County File: OAR2512

City of Colorado Springs Project: ZONE-25-0021 - BLR Village C - MX-M Rezone

LUPL-25-0008 - BLR Village C - Land Use Plan

EPC DPW has the following comments:

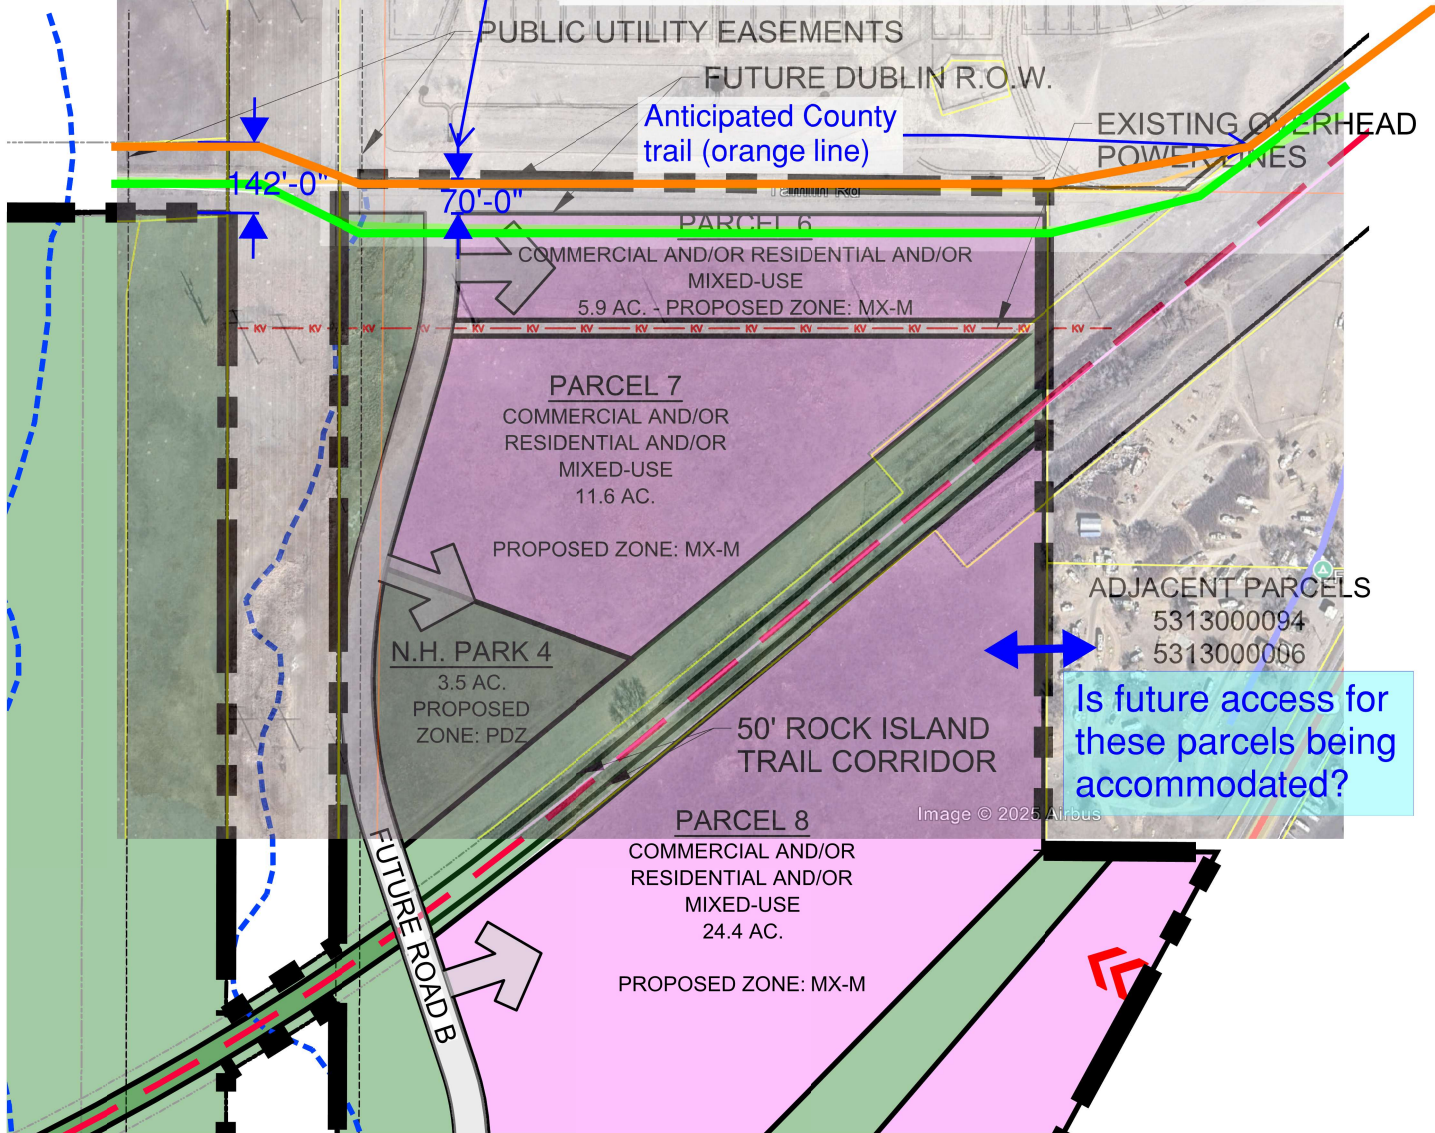
1. Note: Coordination is needed between the developer, the City and EPC (DPW and Parks) regarding the Dublin Blvd./Falcon Highway alignment. See attached sketch/redlines.
